**EL PASO COUNTY PLANNING AND
 COMMUNITY DEVELOPMENT
 DEPARTMENT**

GRADING AND EROSION CONTROL PLAN CHECKLIST
EPC Project Number (SF-22-XXX) 22-041

**SITE MAP/ GRADING, EROSION CONTROL PLAN**

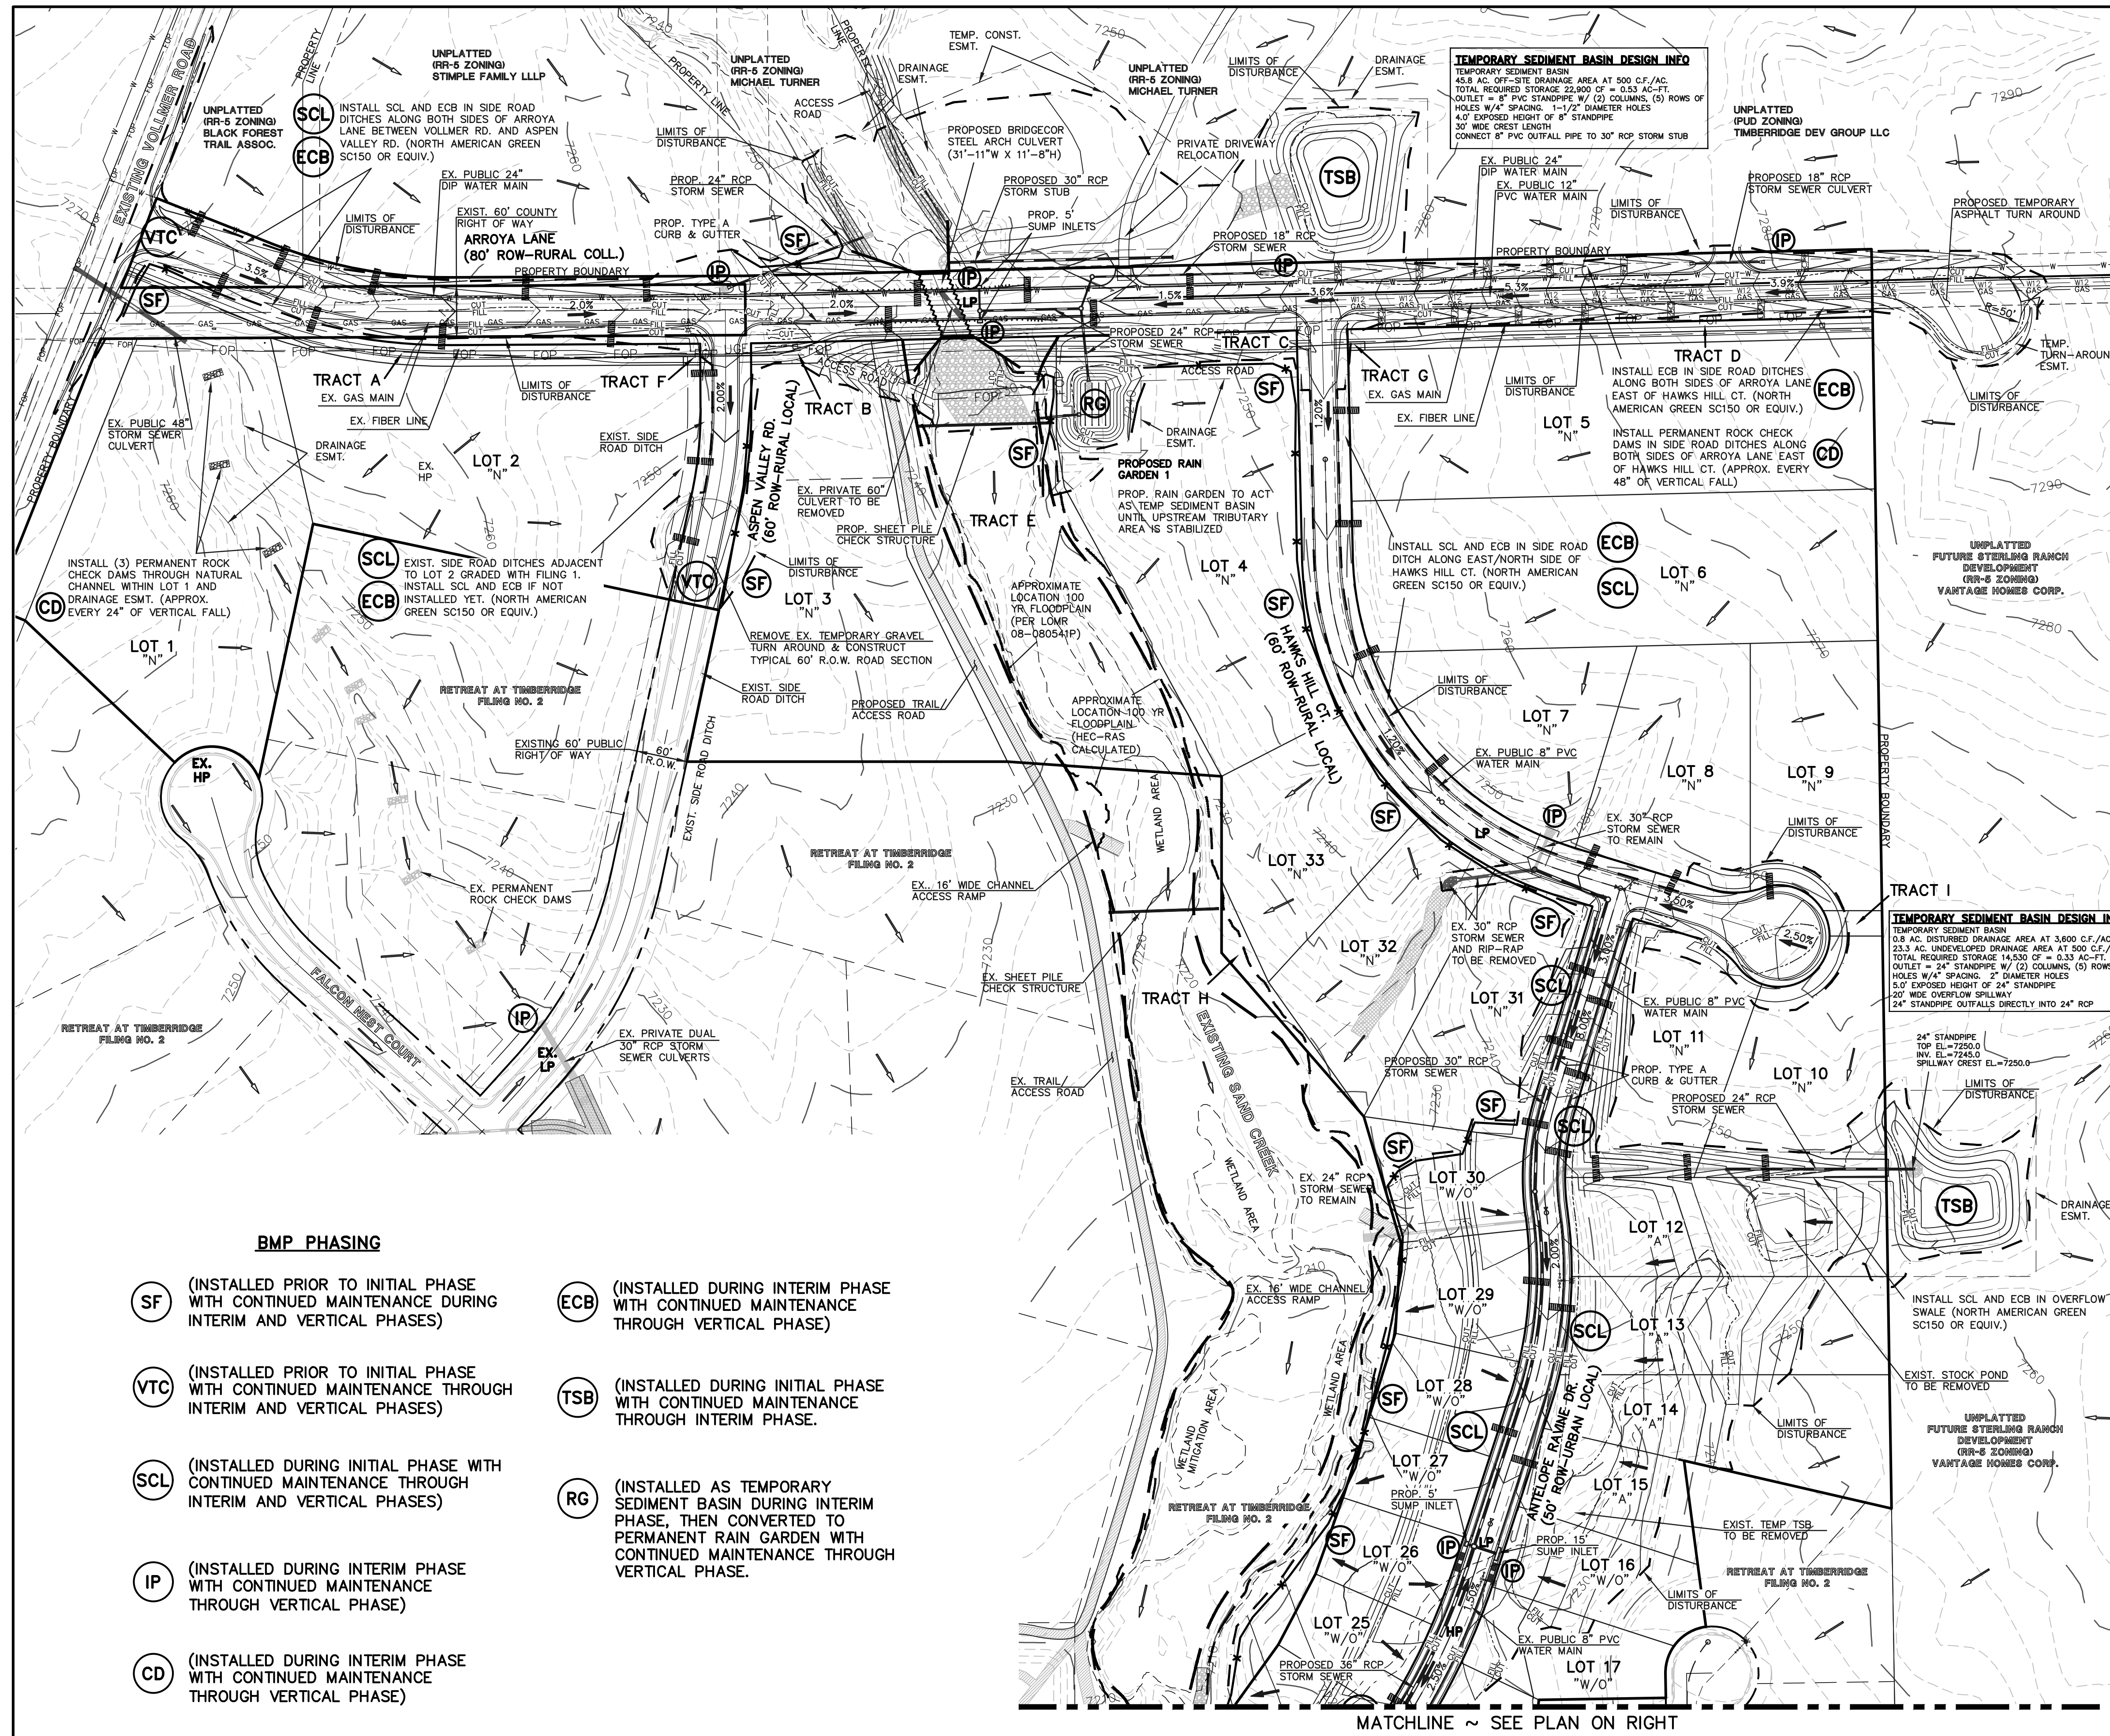
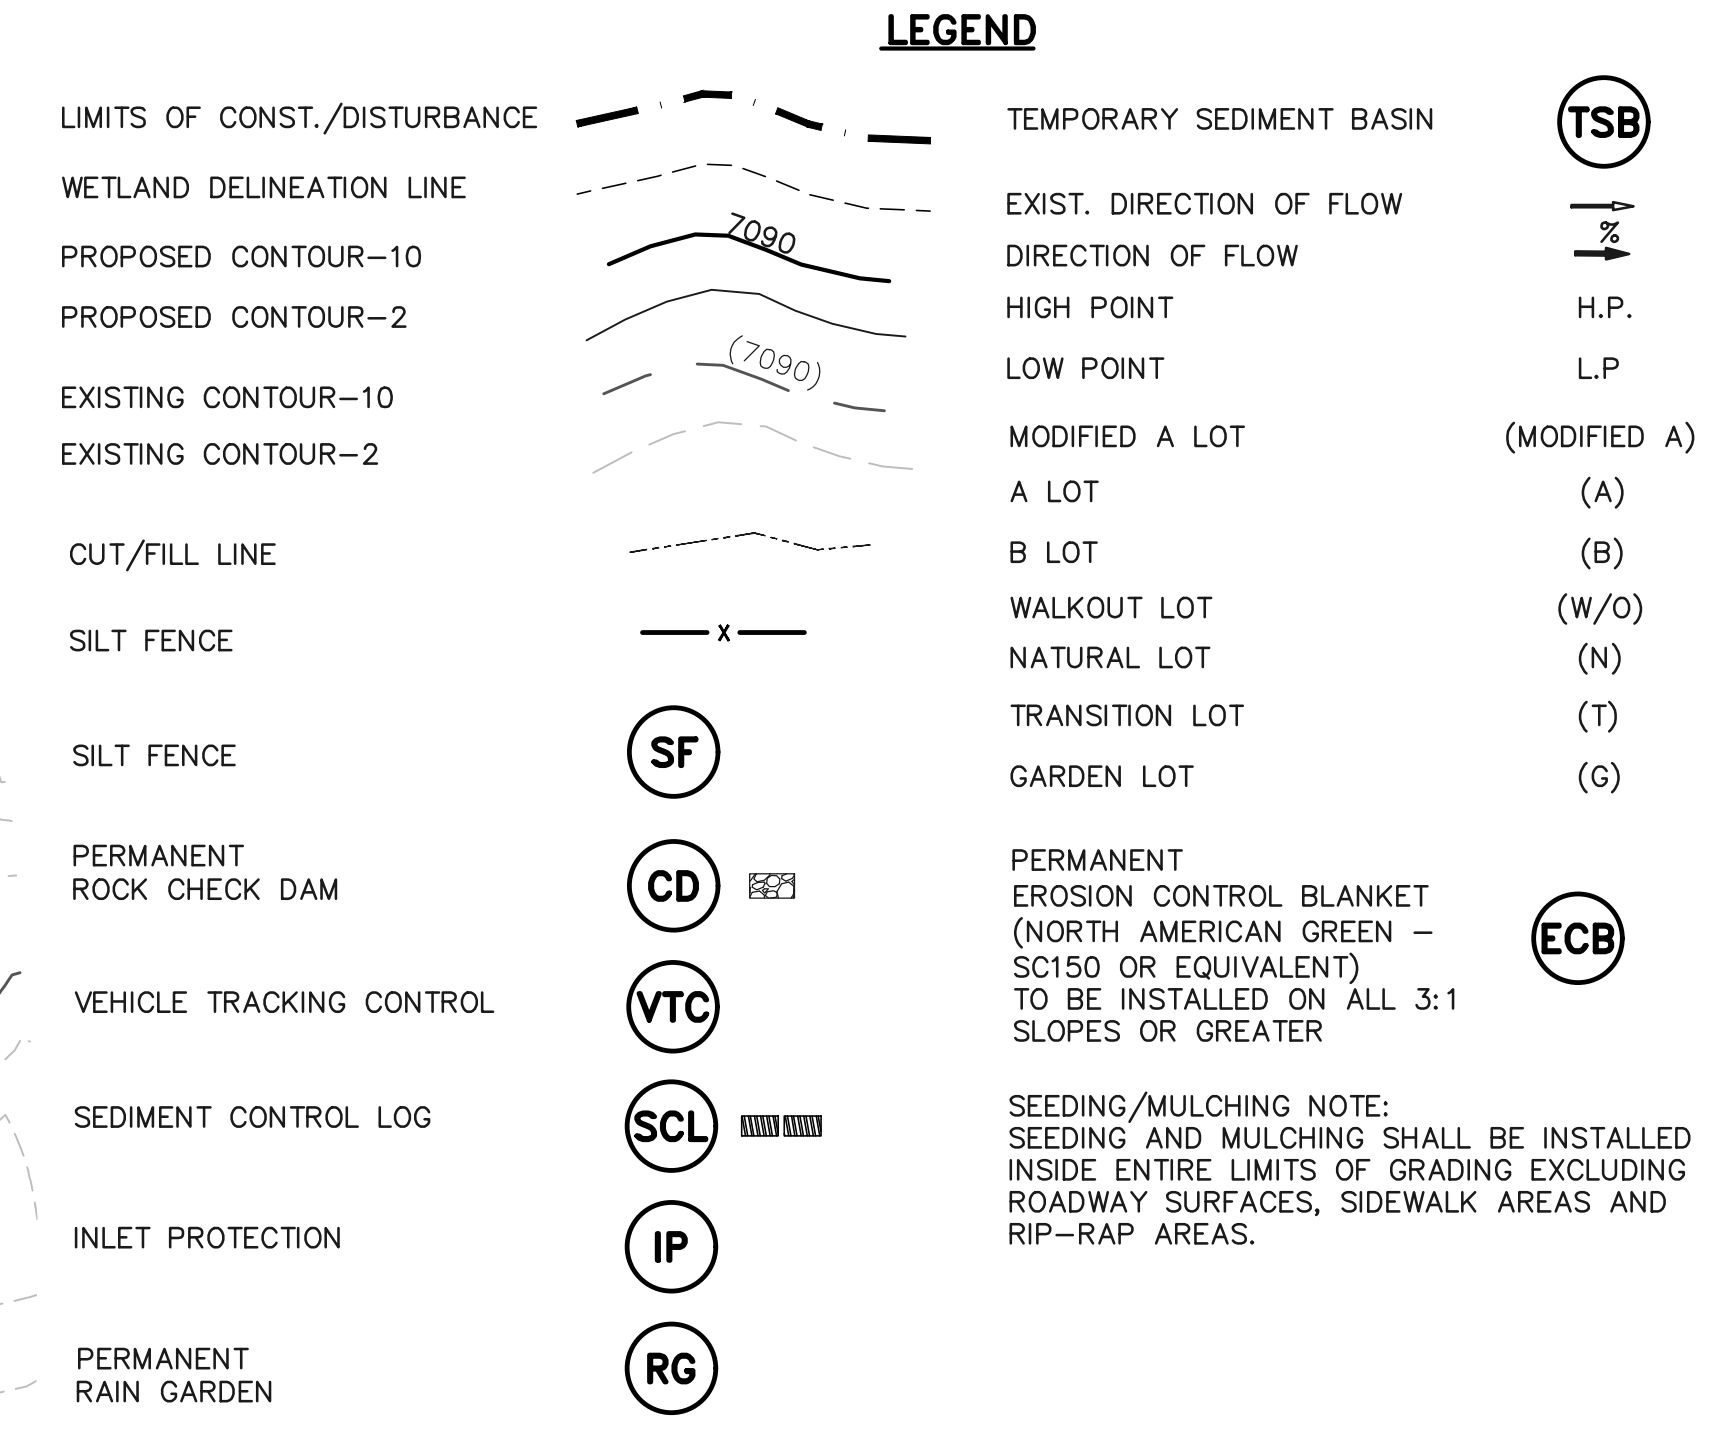
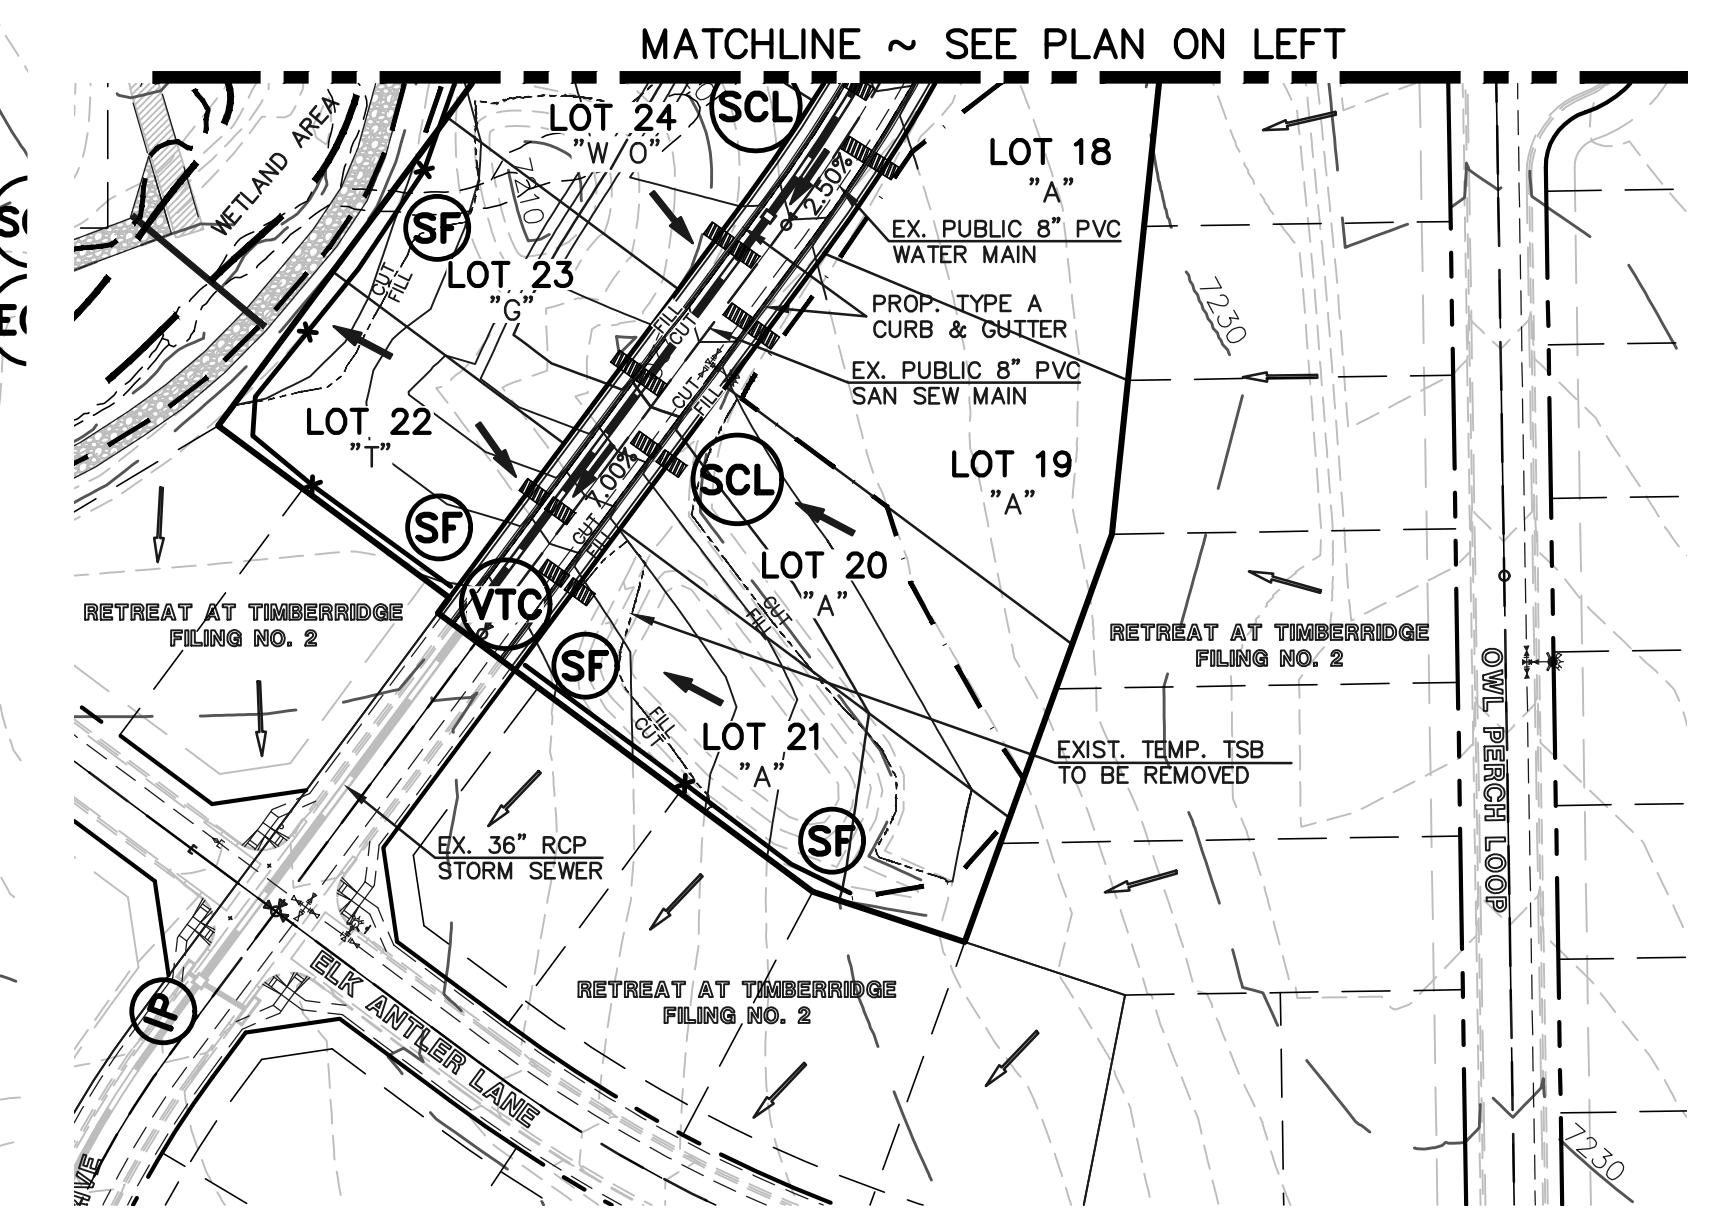
| | | Applicant | PCD |
|--|---|-----------|-----|
| e | Existing and proposed property lines. Proposed subdivision boundary for subdivision projects. | X | ✗ |
| p | Areas of cut and fill identified. | X | ✗ |
| s | Stormwater flow direction arrows. | X | ✗ |
| w | Vehicle tracking provided at all construction entrances/exits. Construction fencing, barricades, and/or signage provided at access points not to be used for construction. | X | ✗ |
| z | All proposed temporary construction control measure details. Custom or other jurisdiction's details used must meet or exceed EPC standards. | X | ✗ |
